**Environment Department  
County Hall  
Pegs Lane  
Hertford SG13 8DN**

Our Ref: WH/286/2011  
Your Ref: S6/2011/1994/MA  
Tel: 01992 556120  
Fax: 01992 588601

**Redevelopment of Salisbury Square; demolition of existing shopping parade building with 7 maisonettes above including retaining wall structures; construction of new road and layout of public spaces; erection of new building containing 19 flats and 4 shops with basements; new two level car park; erection of terrace of 5 houses with road and footways; access alterations, drainage and all ancillary works**

**Application No. S6/2011/1994/MA**

FIGURE No:  
**1458/SK/001**

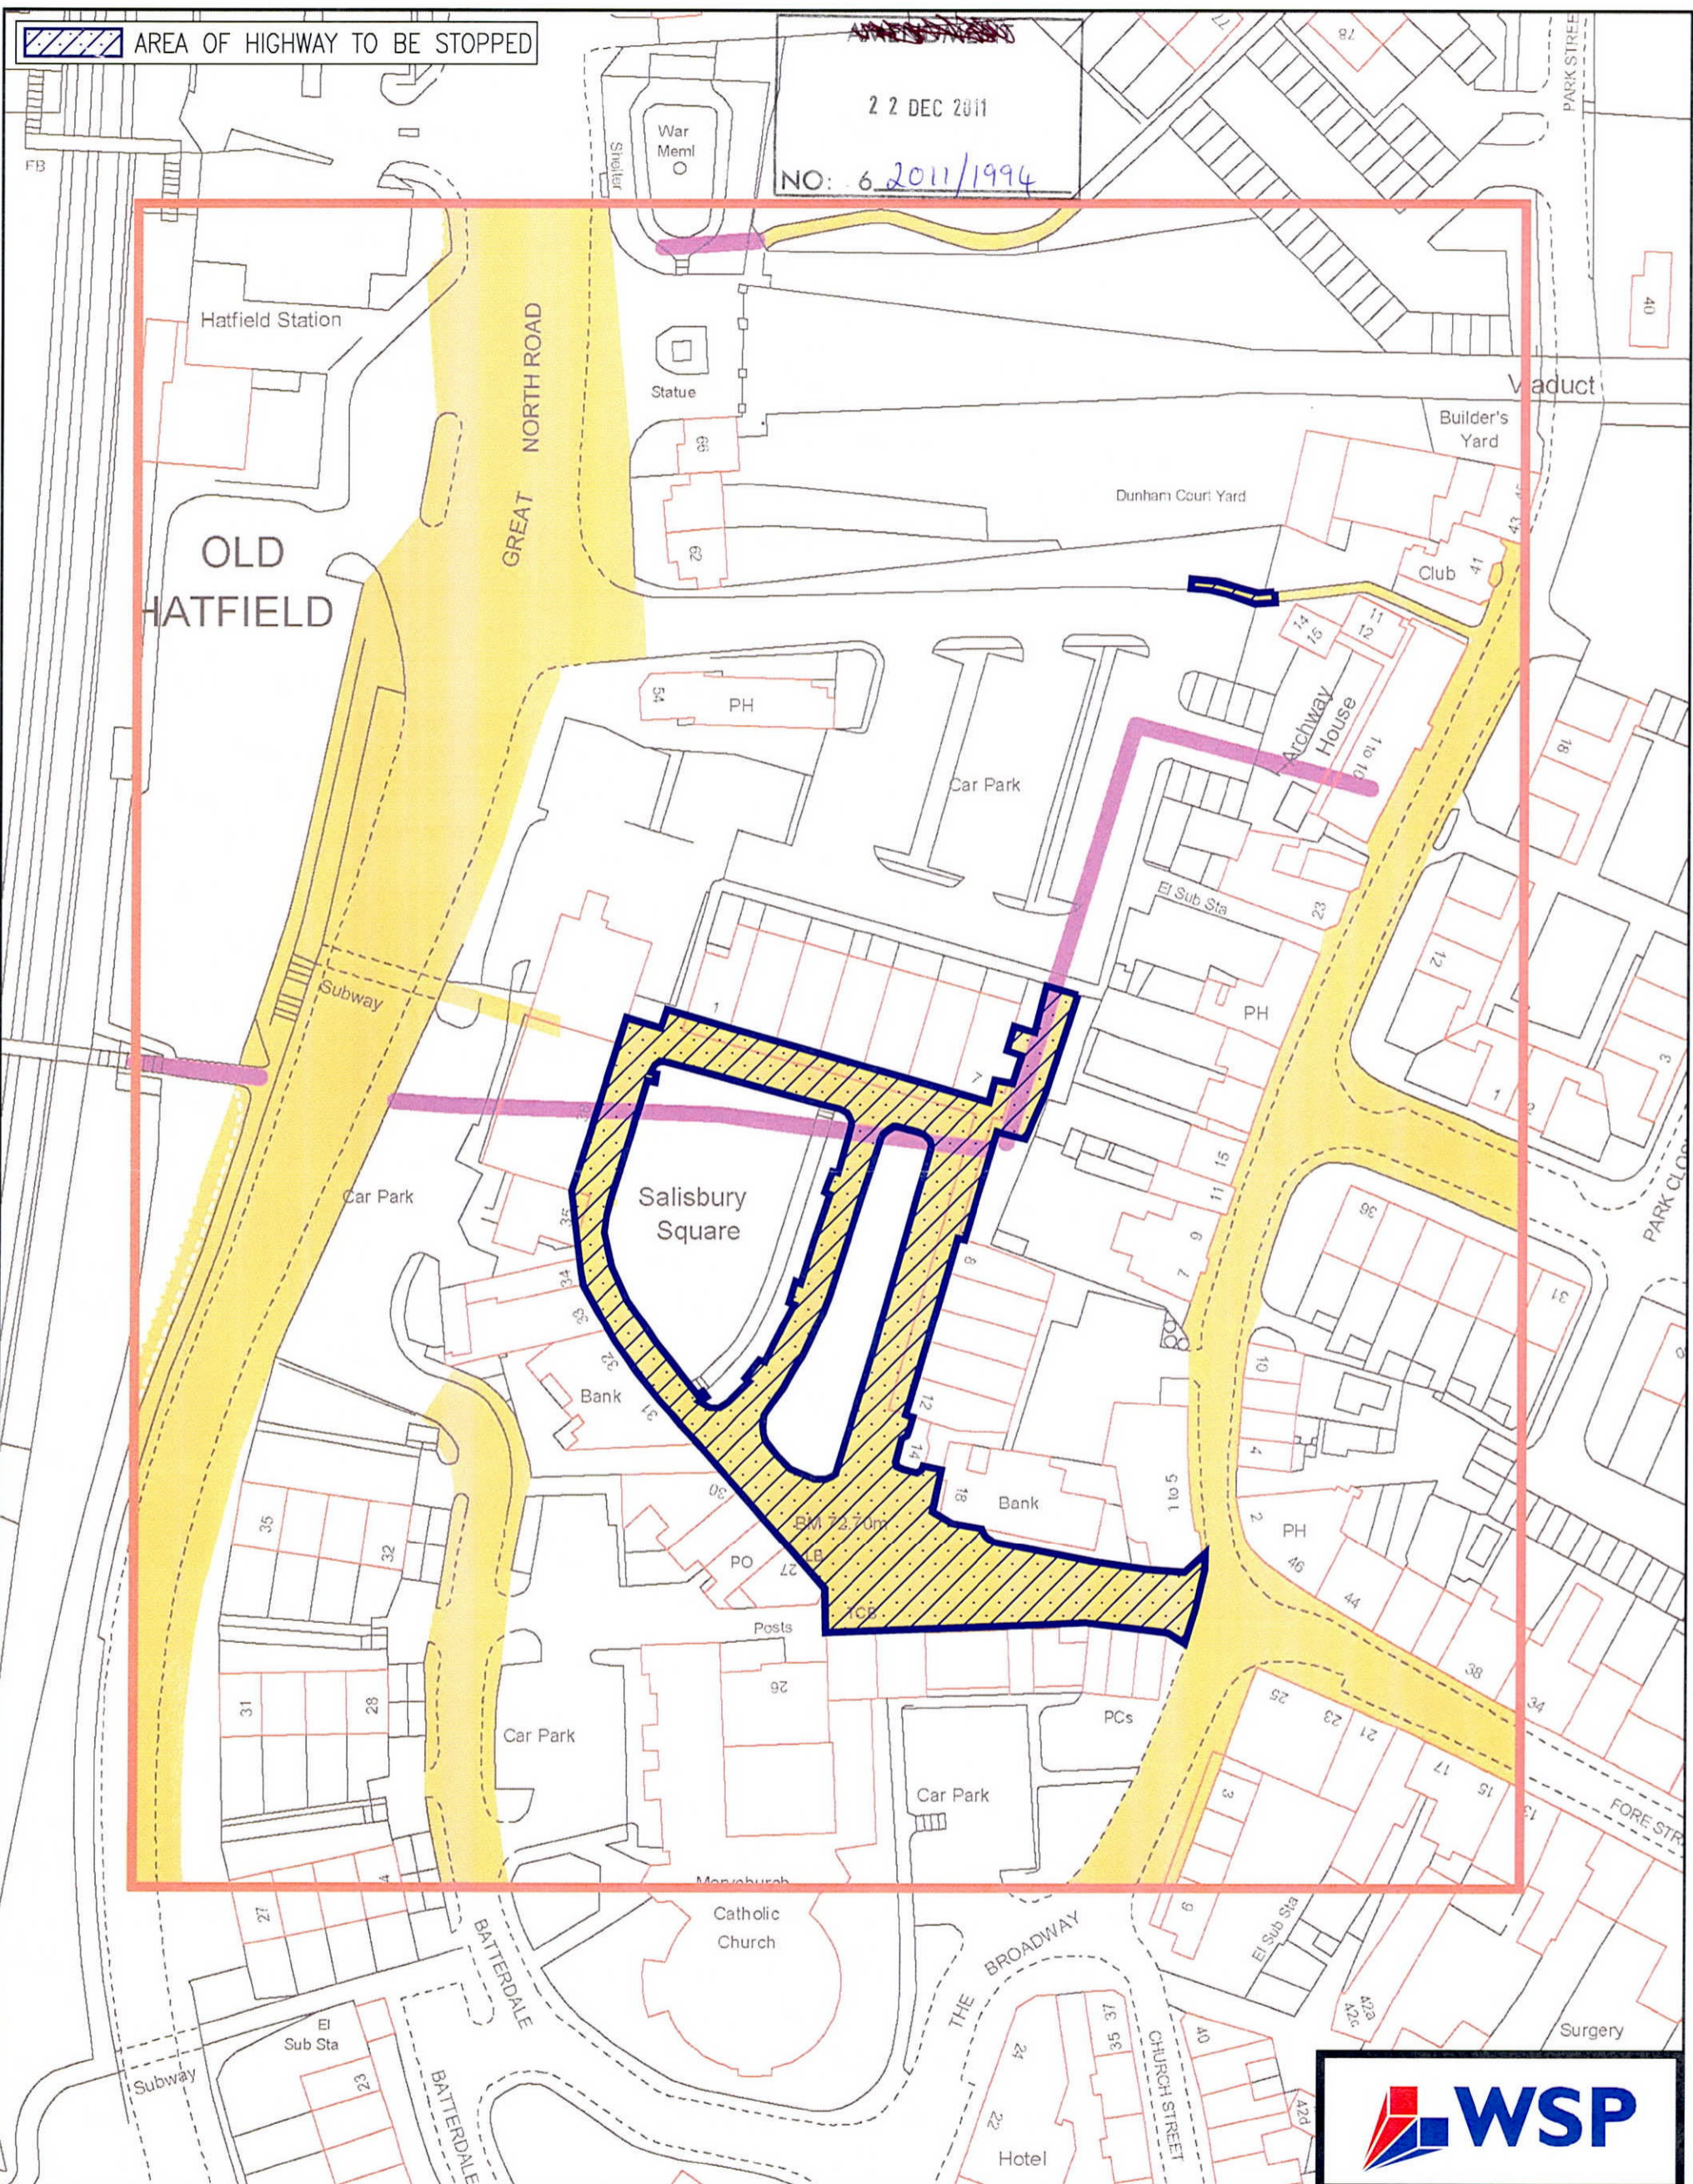
A large proportion of the roads in the site are currently classified as public highway. The applicant has stated in that the internal roads are intended to become 'stopped up' and become privately maintained. The applicant has provided a plan (1458-SK-001) which indicates the area of the highway to be stopped up. The highway authority has no objection to the principle or the extent of the stopping up but consideration must be given to the rights of access for any Park Street (and other) properties with rear access to the existing highway in the area.

DRAWING TITLE:
Proposed Site plan - Ground level

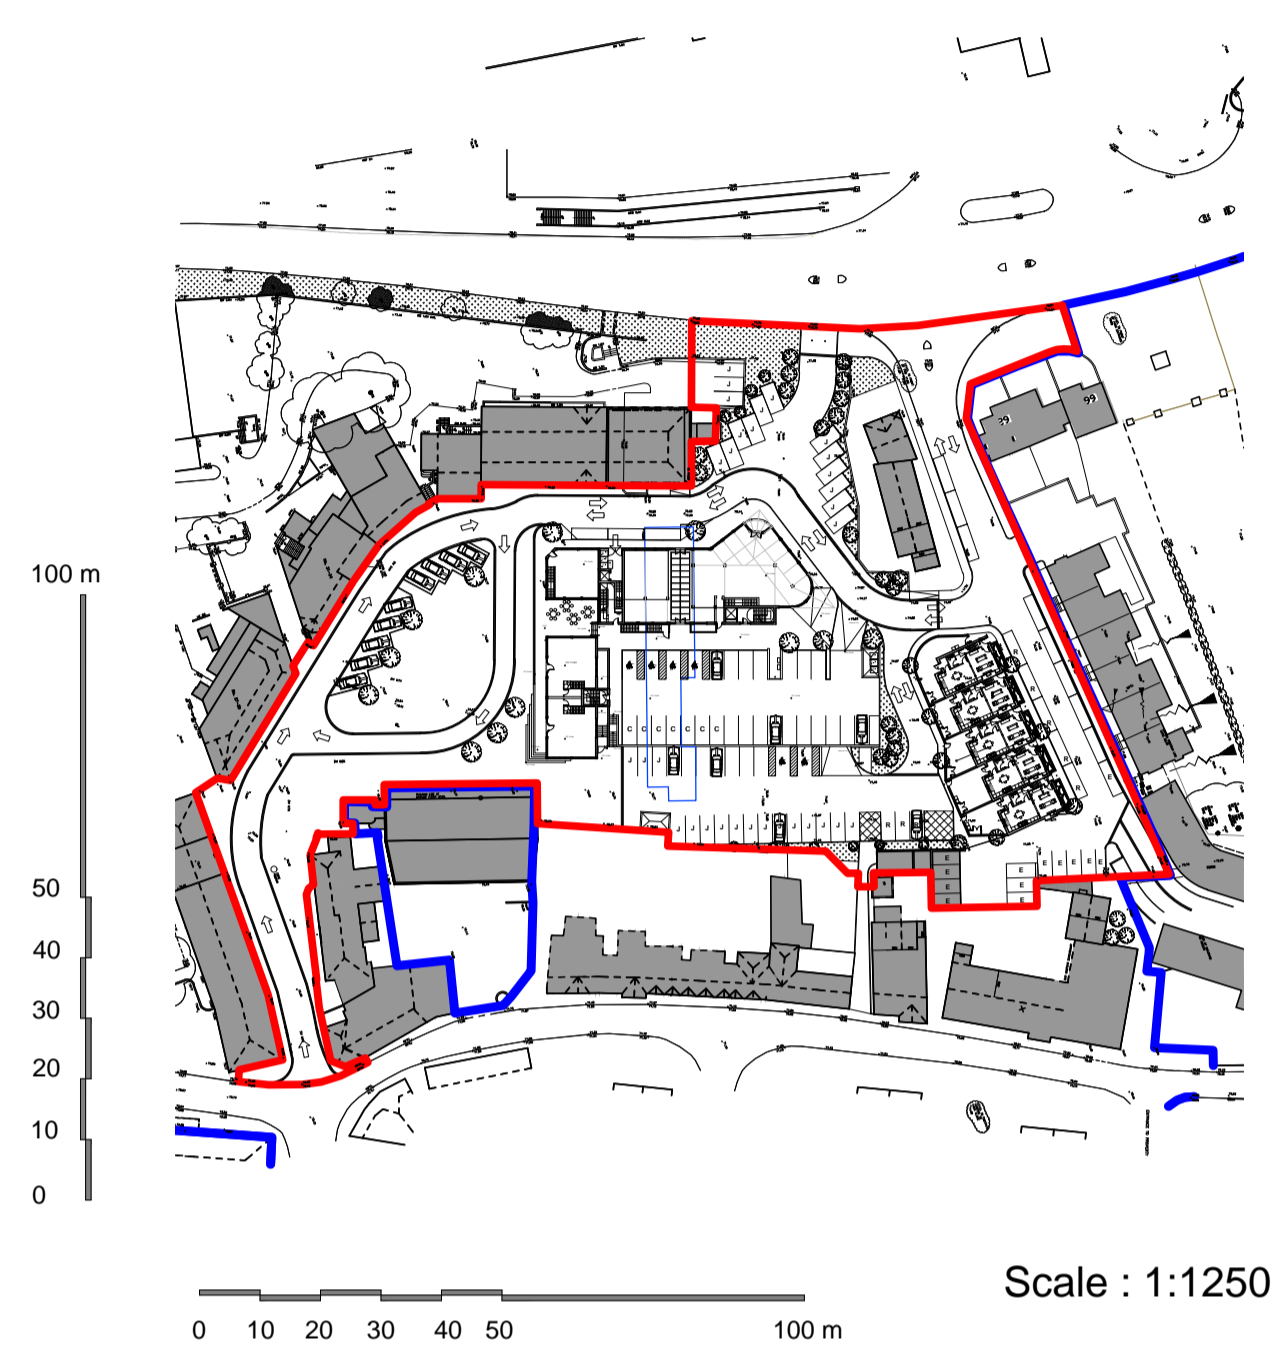
A new vehicular access, allowing entry only, is proposed from Park Street to the southeast of Salisbury Square at a point approximately opposite Fore Street. The new vehicular access will allow local traffic to access the proposed retail units and residences from Park Street, whilst restricting through traffic from Great North Road to Park Street.

There is currently a pedestrian access to Salisbury Square opposite Fore Street. The proposal includes reconstructing this area to allow vehicles to enter Salisbury Square from this direction. The road will be narrow and it will operate in a one direction, vehicles will not be permitted to exit into Park Street from this direction. The nature of the road and the initial design being put forward by the applicant will naturally lead to low vehicle speeds.

1. Prior to occupation of the development the proposed new access to the site from Park Street/The Broadway and the pedestrian route to Great North Road shall be completed and constructed to the satisfaction of the Local Planning Authority in consultation with the Highway Authority.
